Thanet Extension Offshore Wind Farm

Annex A to Appendix 8 to Deadline 8 Submission:
Log of Changes to the draft Development
Consent Order

Date: June 2019

Revision H

Onshore Street Work Plans - Sheet 1 of 2

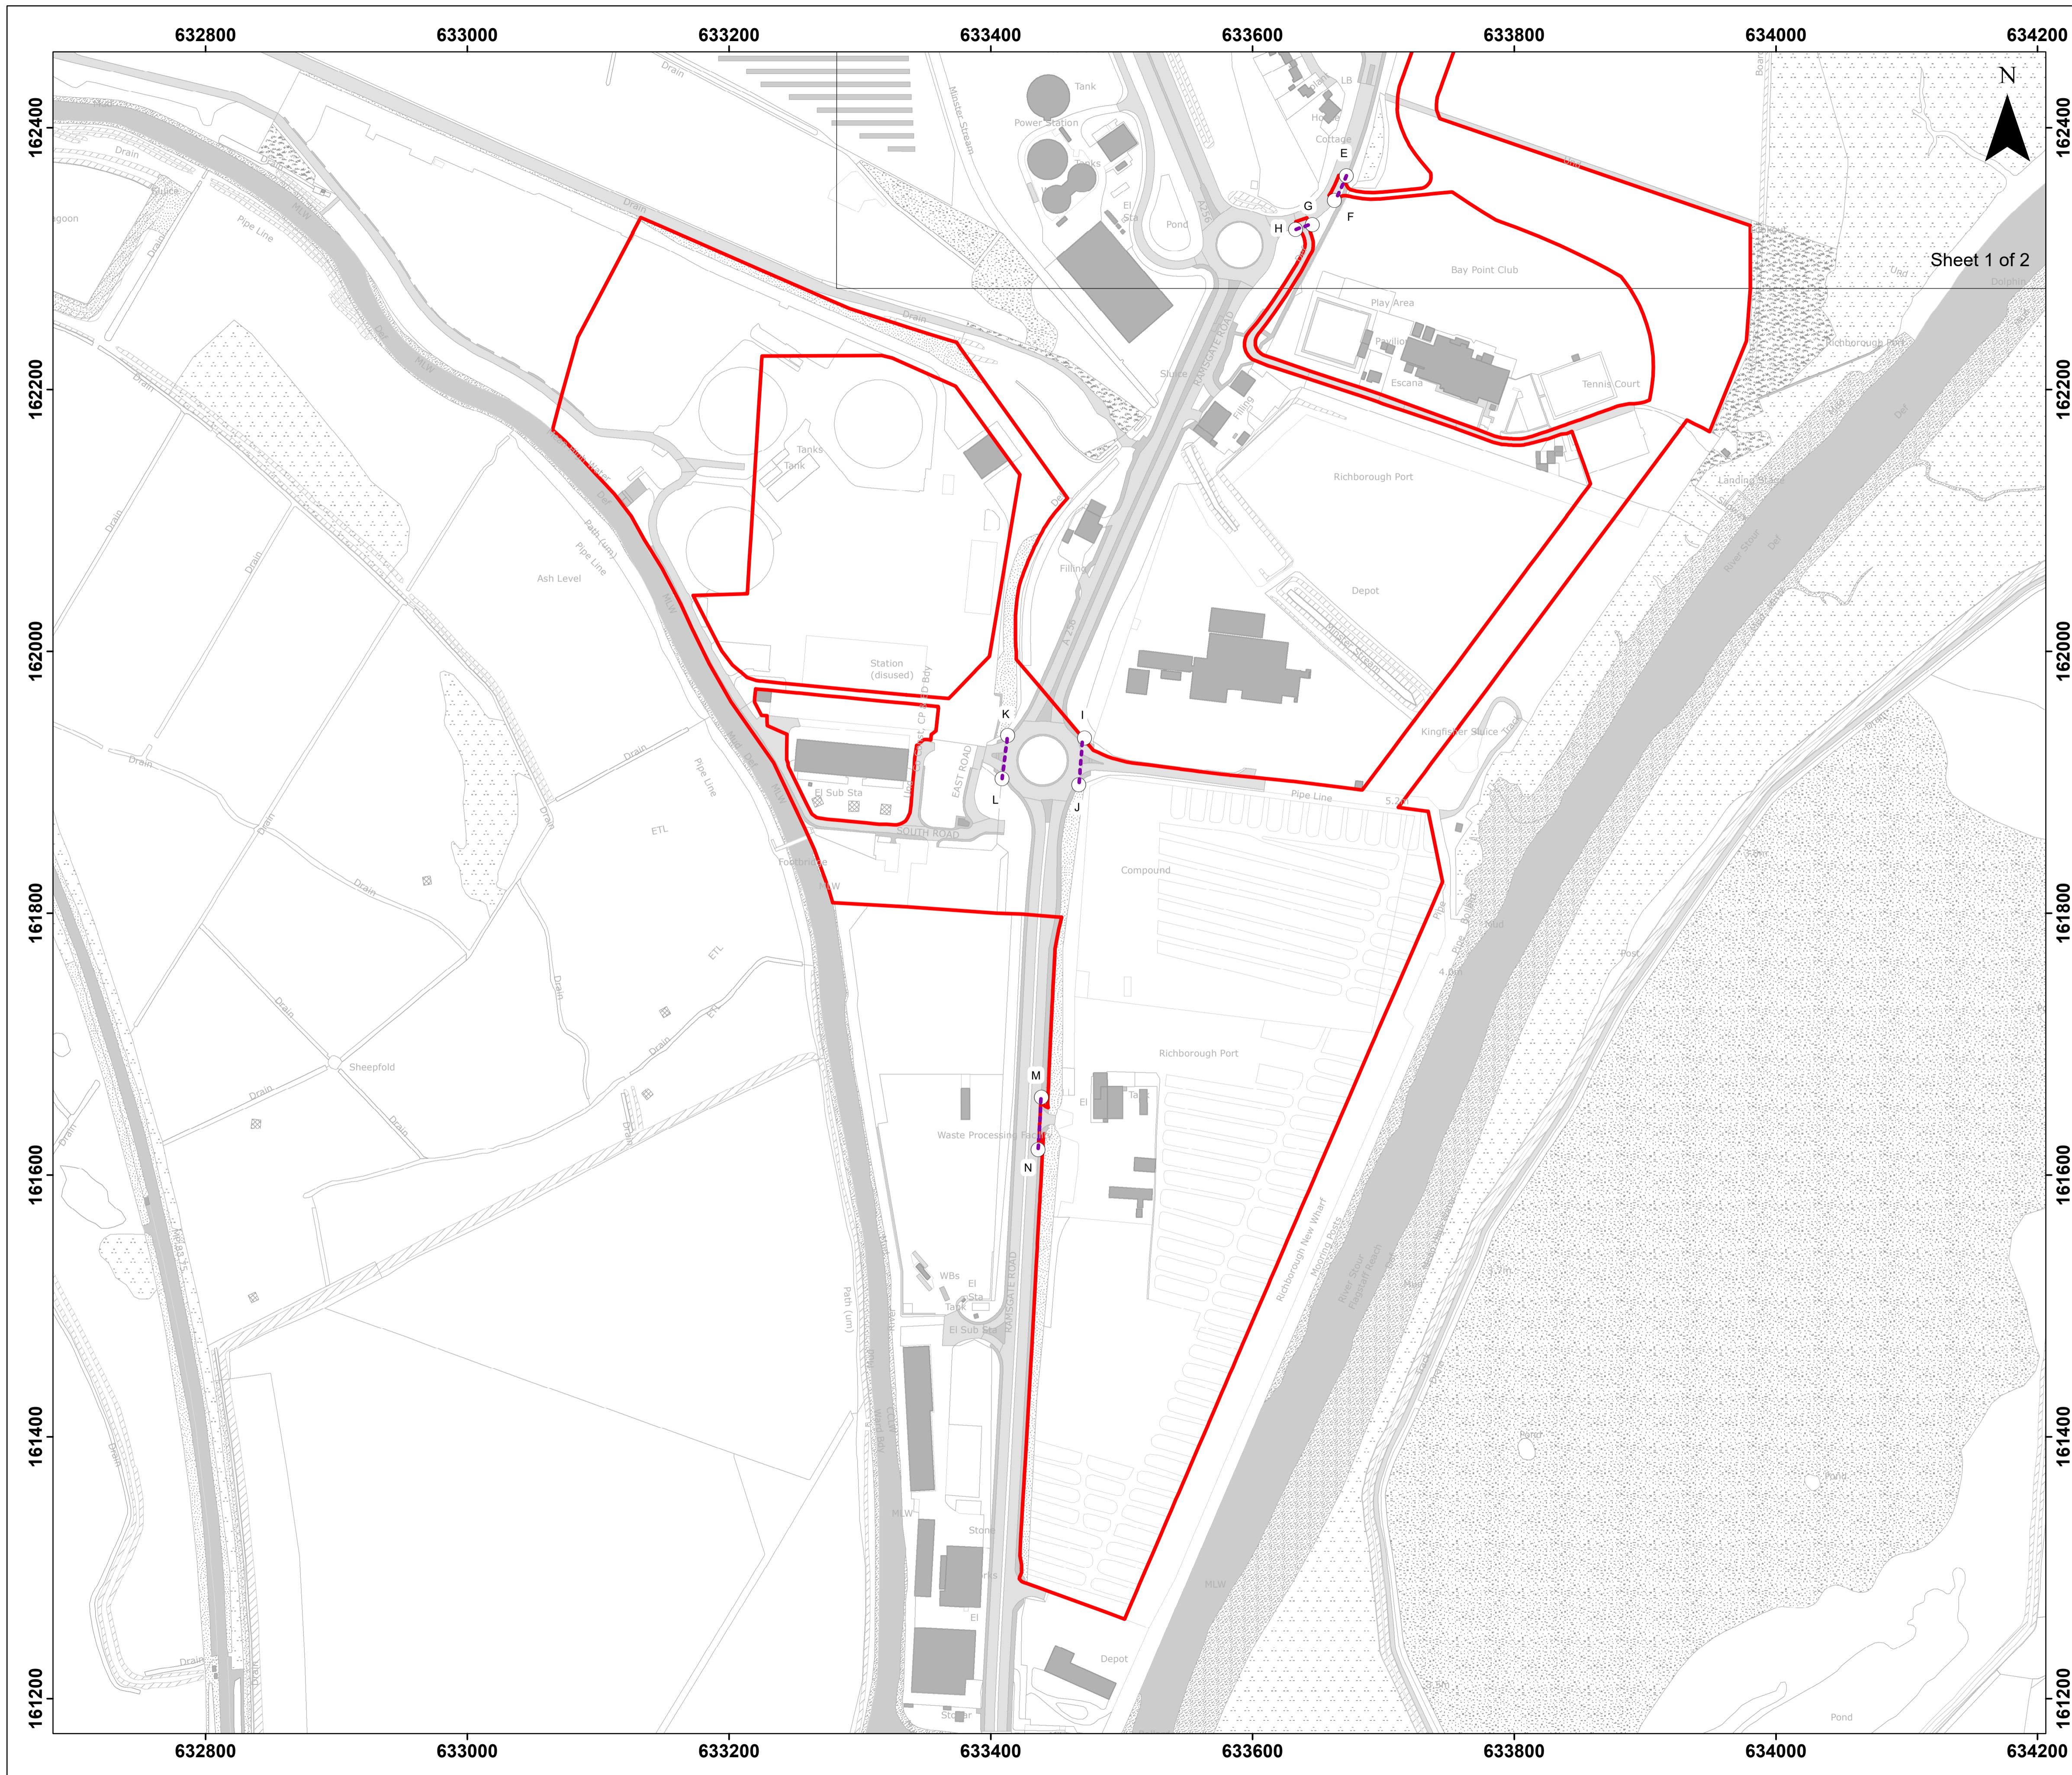
Ref	DCO Ref.	Rationale for change	Change made	DCO Version
1.	Schedule 2	In their Section 51 advice issued to the Applicant, the Planning Inspectorate noted that: "In relation to the dDCO Schedule 2, the dDCO refers to the works plans. This should be the onshore street works plans."	The wording has been amended throughout Schedule 2, for example – <i>SANDWICH ROAD at reference point A-B on the <u>onshore street</u> works plan</i>	2
